From: Ivonblumerarchitects <[REDACTED]>
Sent: 11 November 2019 17:36
To: Amber Willard <Amber.Willard@arun.gov.uk>
Subject: Re: aw/258/19/hh

AW/258/19/HH at 26 Barrack Lane.

10714/04

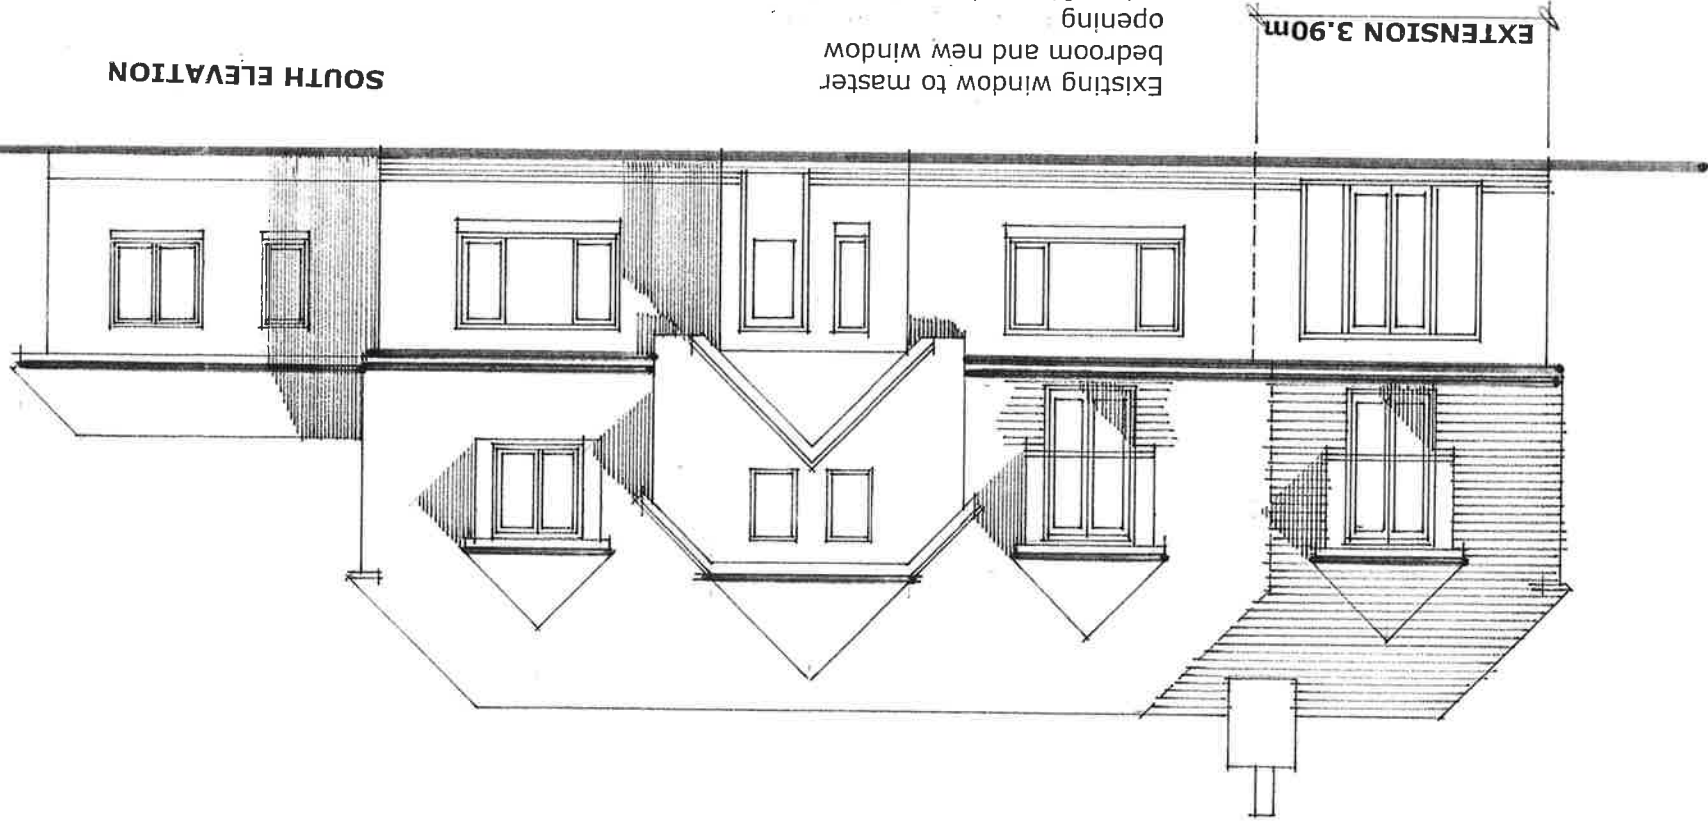
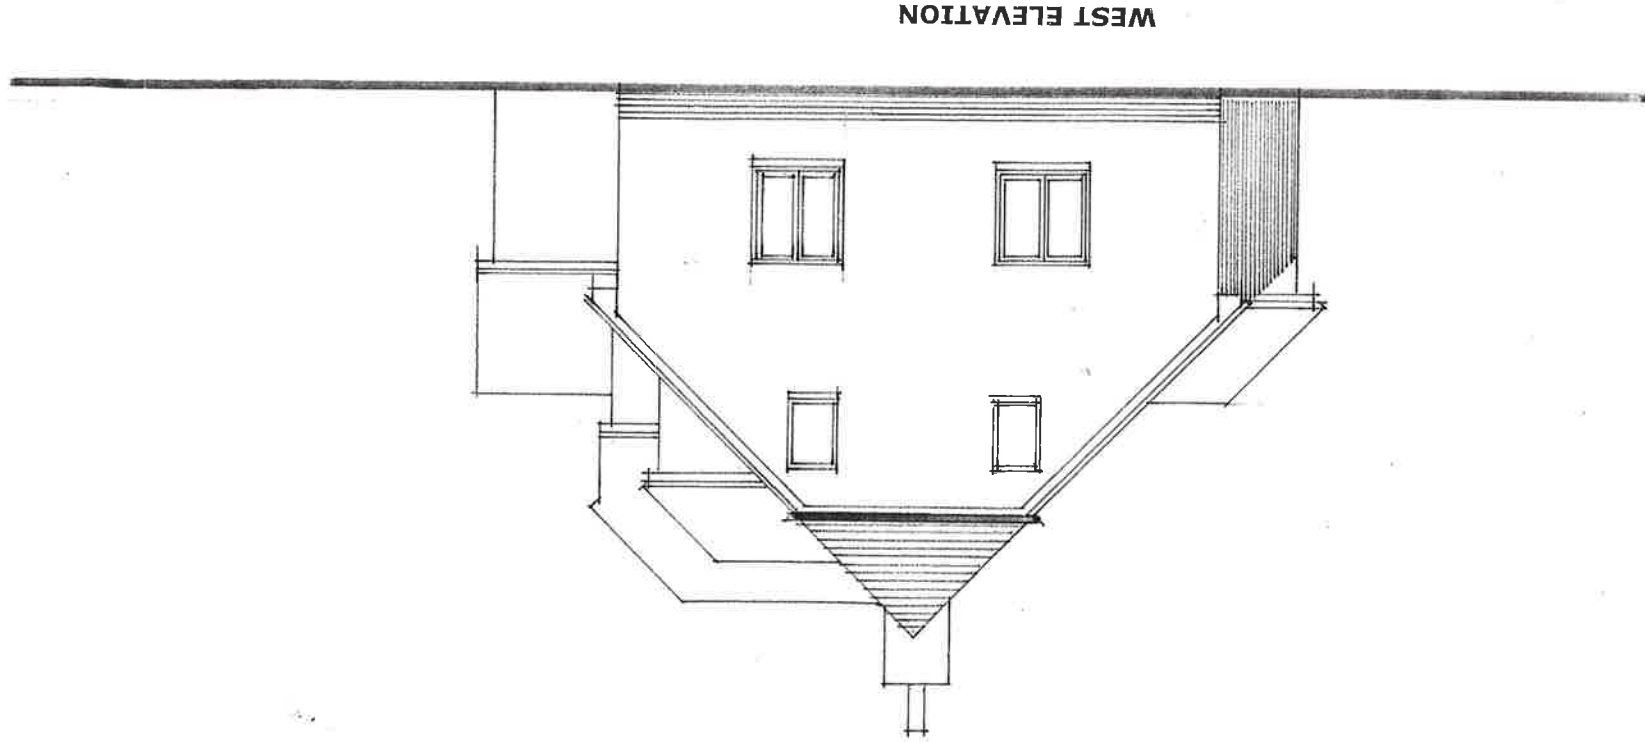
I am just writing up the application however I note the scale does not appear correct on the elevation plans. It says 1:50 however it should be 1:100. Please can this be amended on the plans.

The drawings are copies for which I was not the author. I believe they are copies of the drawings used in the previous applications. Would it be acceptable if I authorised you/ADC to manually amend the scale. This is all I can do in any case.
